Application Ref:	3/2026/0340			 Ribble Valley Borough Council www.ribblevalley.gov.uk
Date Inspected:	19/06/26	Site Notice:	19/06/2026	
Officer:	AR			
DELEGATED ITEM FILE REPORT:				REFUSAL

Development Description:	Proposed first floor extension over existing single storey extension.
Site Address/Location:	53 Riverside Clitheroe BB7 2NS

PROPOSED EAST ELEVATION
SCALE 1:100

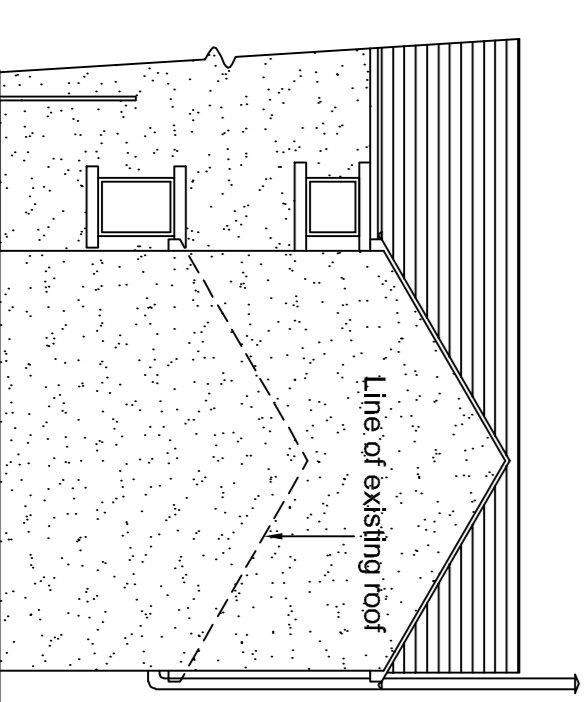
Whilst the proposed development would feature a modest footprint of 5.55m in width and 4.44m in length, the extension would have a significant visual presence due to being situated on the dwellinghouse's front elevation. In addition, the proposed extension features a maximum height of 6.73m, being set down from the main ridge by only 0.13m. Whilst two-storey and single-storey front extensions are a somewhat common feature in the locality, it is considered the proposed development would have a significant impact upon visual amenity of the street scene and surrounding area, as the development would dominate the front elevation of the dwellinghouse, and not appear subservient with the scale of the main dwelling.

Furthermore, the proposed development is considered to be of poor design quality, with the front elevation featuring a blank façade that would result in a monotonous, unsympathetic appearance to the dwellinghouse.

PROPOSED NORTH ELEVATION
SCALE 1:100

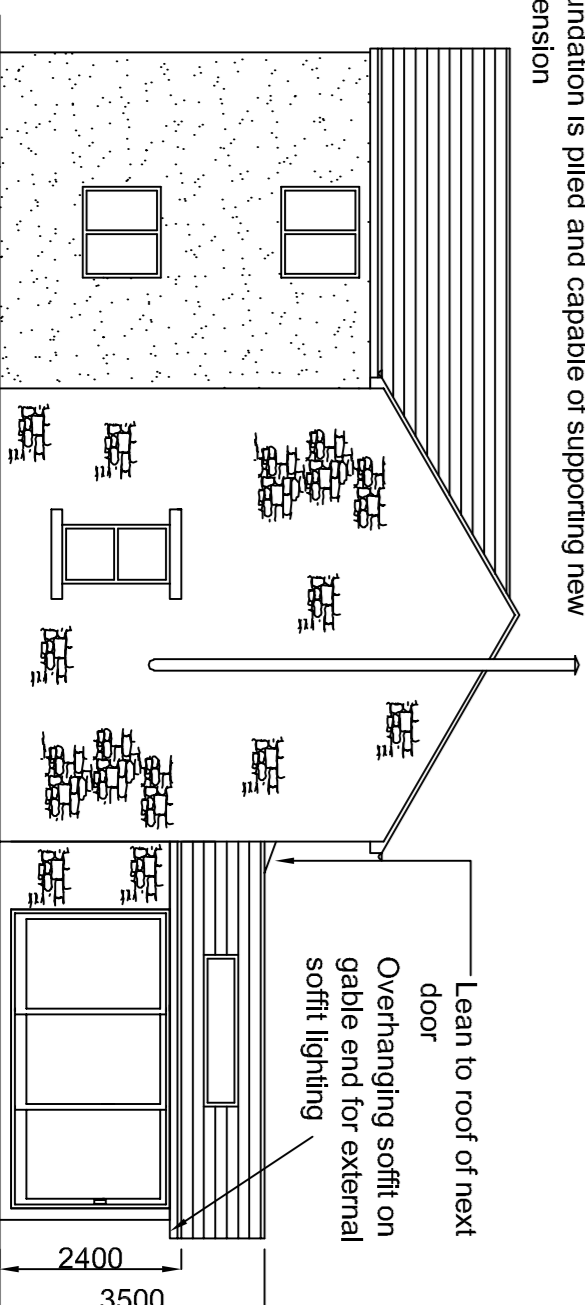
With respect to the potential impact on adjacent neighbours, the proposed window to the extension's north elevation would look over the existing boundary treatment, directly into the residential amenity space of No. 61 Riverside. As there are currently no first-floor windows on the northern elevation of No. 53 Riverside, the introduction of this window would result overlooking and an undue loss of privacy and for occupants of No. 61.

PROPOSED SOUTH ELEVATION
SCALE 1:100

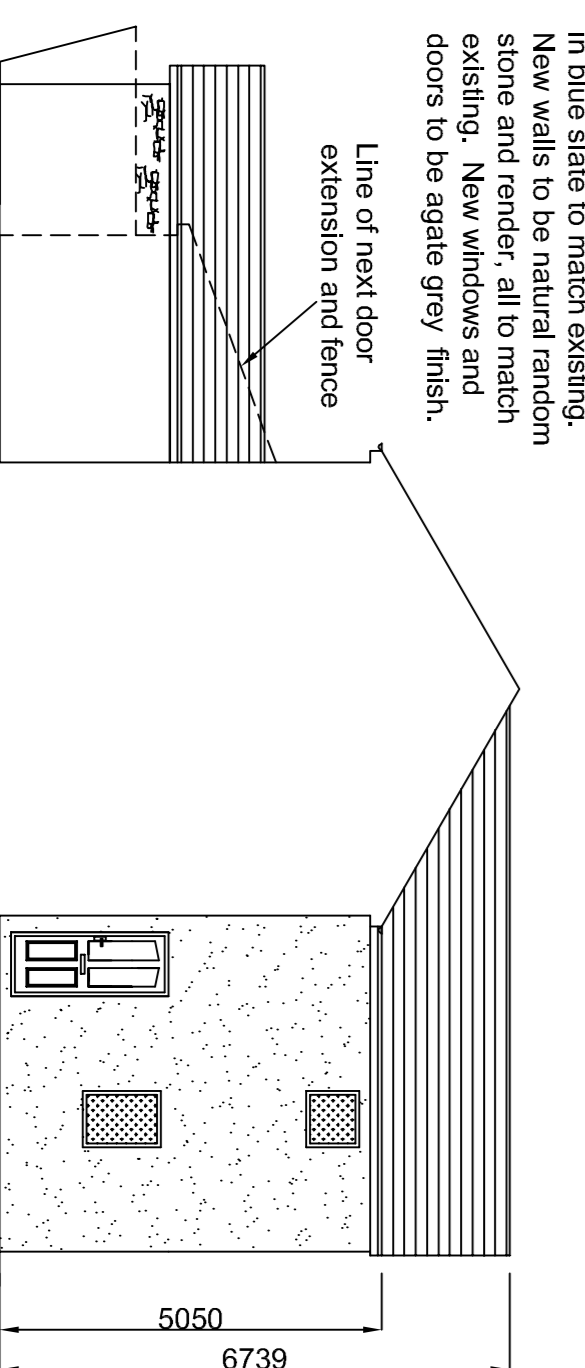
It is important to note that the planning officer requested several amendments prior to determining this application to ensure the proposal's acceptability. The key amendment sought was a reduction in the width of the proposed extension, which would also achieve a lower ridge height. Additionally, the officer requested changes to fenestration details, including removing the window on the northern elevation to address concerns about overlooking and potentially enlarging the window on the southern elevation to increase natural light.
